MONUMENT SMALL ENGINE STORAGE
137 N. Monument Lake Road, Monument, CO 80132
David Hallbusch Office: (719) 471-1937

09 / 24 / 2019

MONUMENT SMALL ENGINE STORAGE FINAL SITE PLAN FOR LANDSCAPE, SIGN & LIGHTING

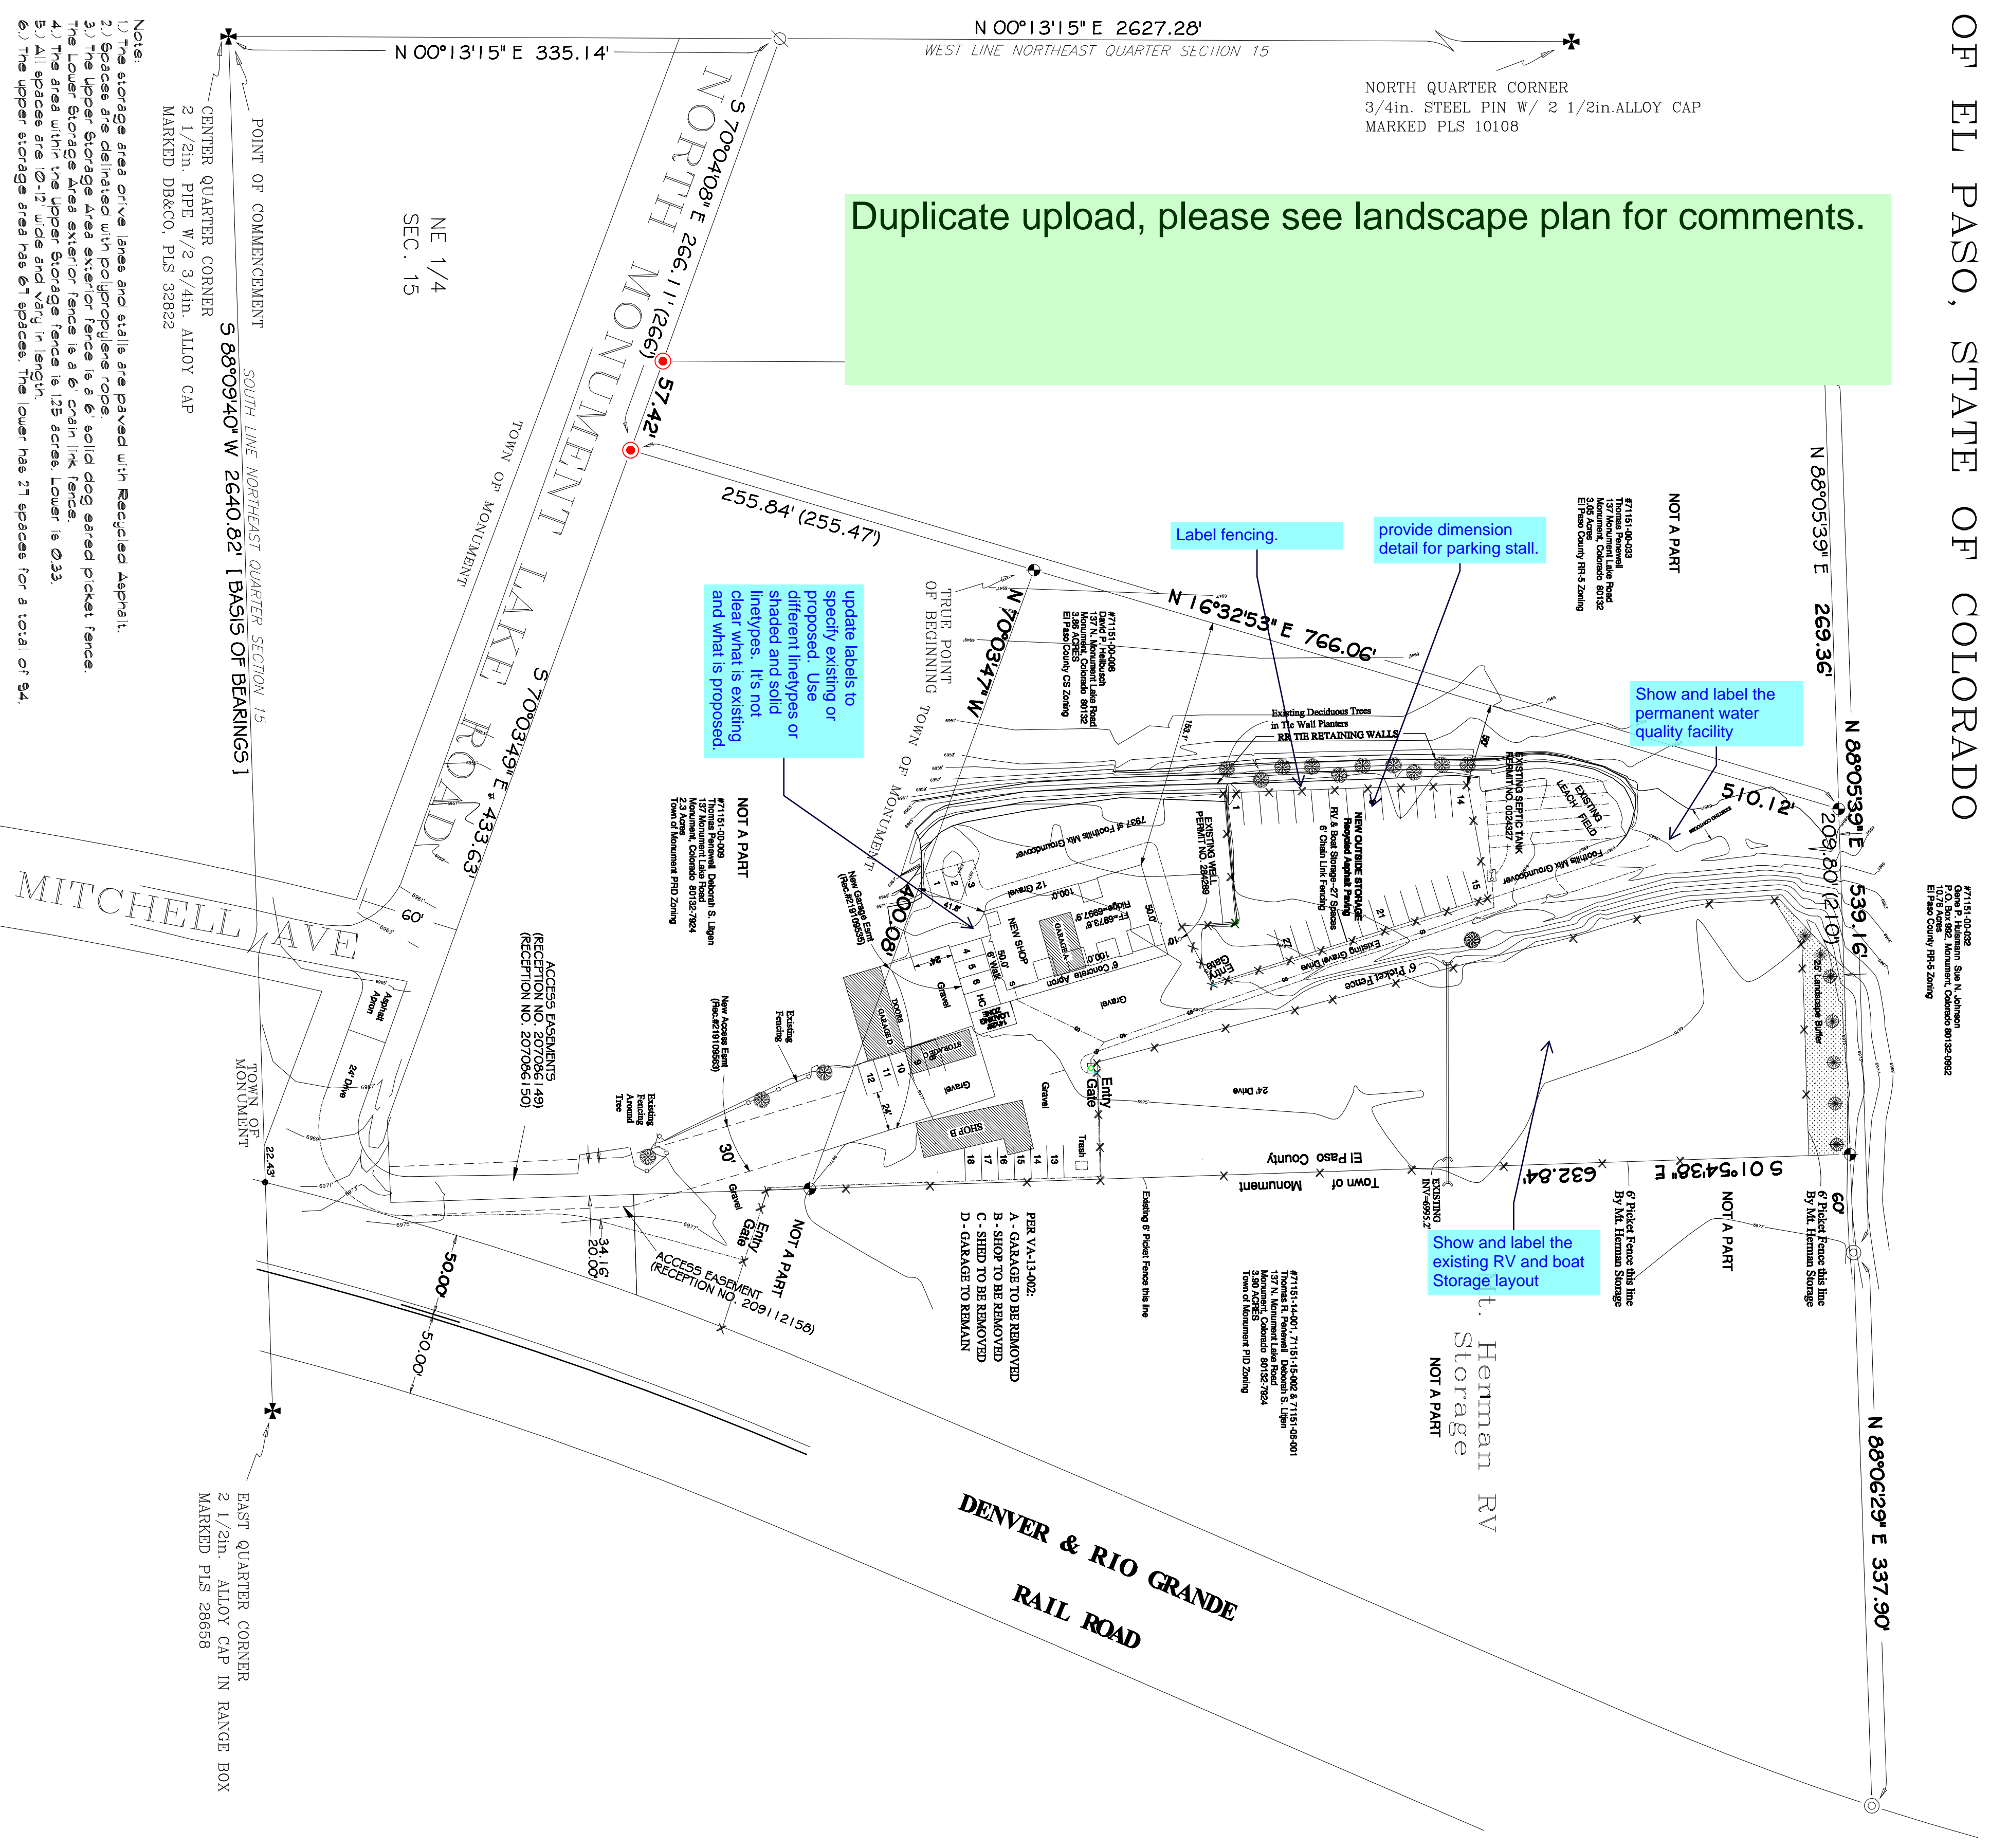
The tree types, minimum planter sizes and utilization of perimeter tree placement shall be consistent with the Landscape and Water Conservation Manual.

The following note should be added to all site development plans or non-residential site plans, as applicable, prior to PCD approval: The parties responsible for this plan have familiarized themselves with all current accessibility criteria and specifications and the proposed plan reflects all site elements required by the applicable ADA design standards and guidelines as published by the United States Department of Justice. Approval of this plan by El Paso County does not assure compliance with the ADA or any regulations or guidelines enacted or promulgated under or with respect to such laws.

- Provide the stages, if appropriate, in which the project will be developed.

Must submit a lighting plan. please see chapter 6.2.3.
